Our Ref: P/25/18/PL

**Town & Country Planning Act 1990 (as amended)
Town and Country Planning (Development Management Procedure) (England) Order 2015
Application for Full Planning Permission**

Development Demolition of existing garage, roof alterations to existing dwelling to provide first floor & 1 No. new dwelling in garden of existing dwelling.
Location Jenin Nyetimber Lane Pagham

Peter J. Gardner Architectural Design Consultant	
	www.architecturaldesignsolutions.co.uk 07967 205249
Job Title	Jenin, Nyetimber Lane Bognor Regis PO21 3JT
Drawing Title	Proposed New Dwelling Floor Plans
Client	R.B
Date	12/05/2017
Drawn	P.J.G
Scale	1:100 on A3
Drq No.	NTL/P/01

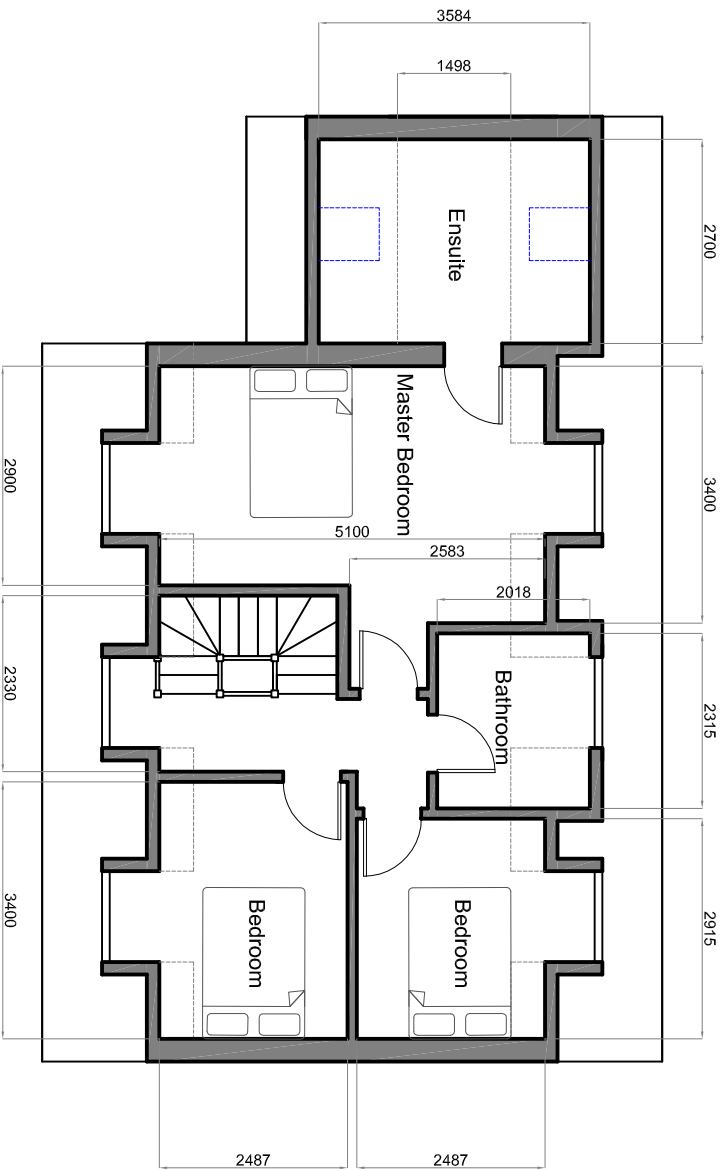
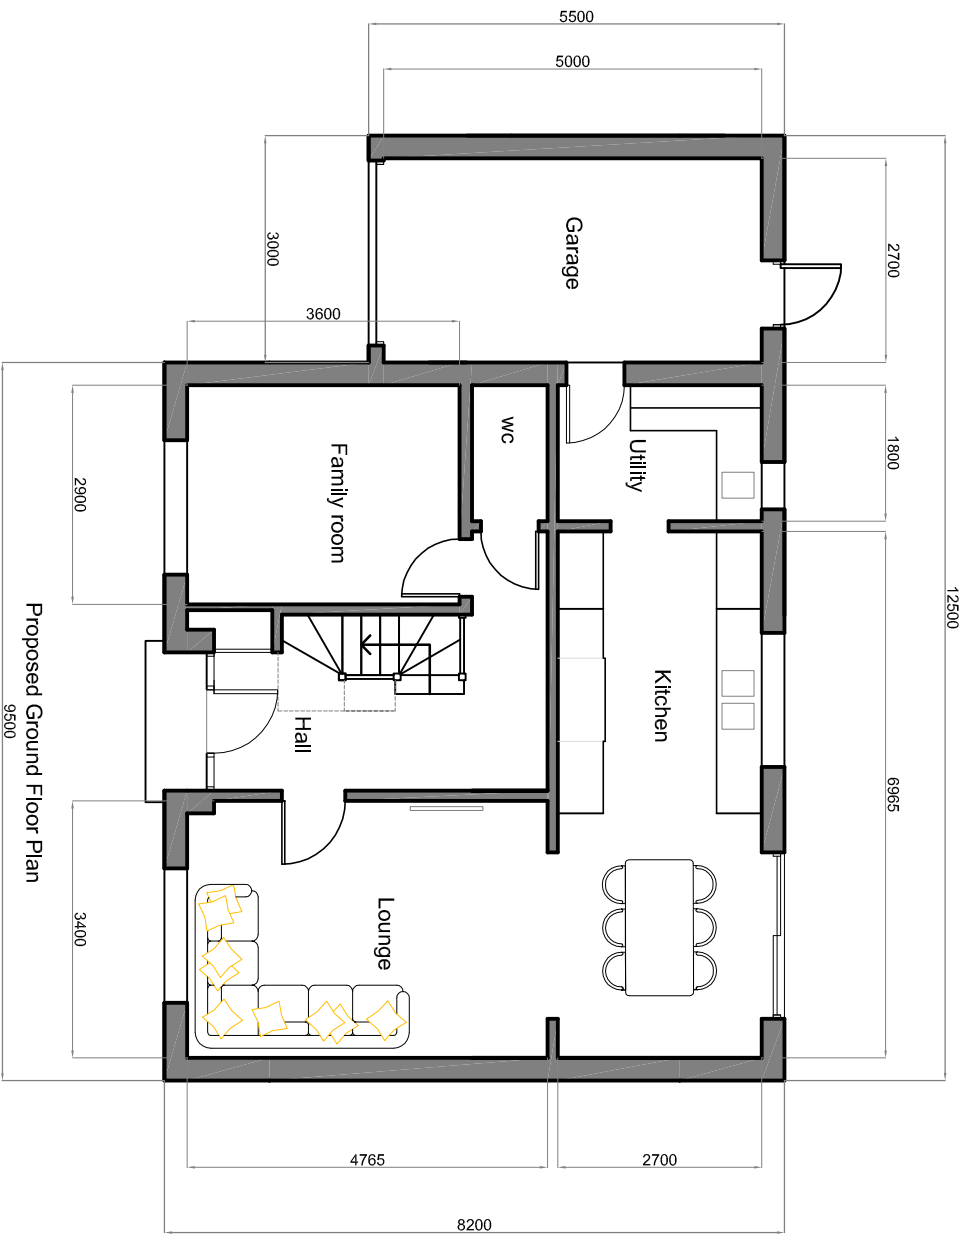
The proposed floor plans and elevations of the new house do not accord. Please check the floor plans and elevations and make the changes accordingly.
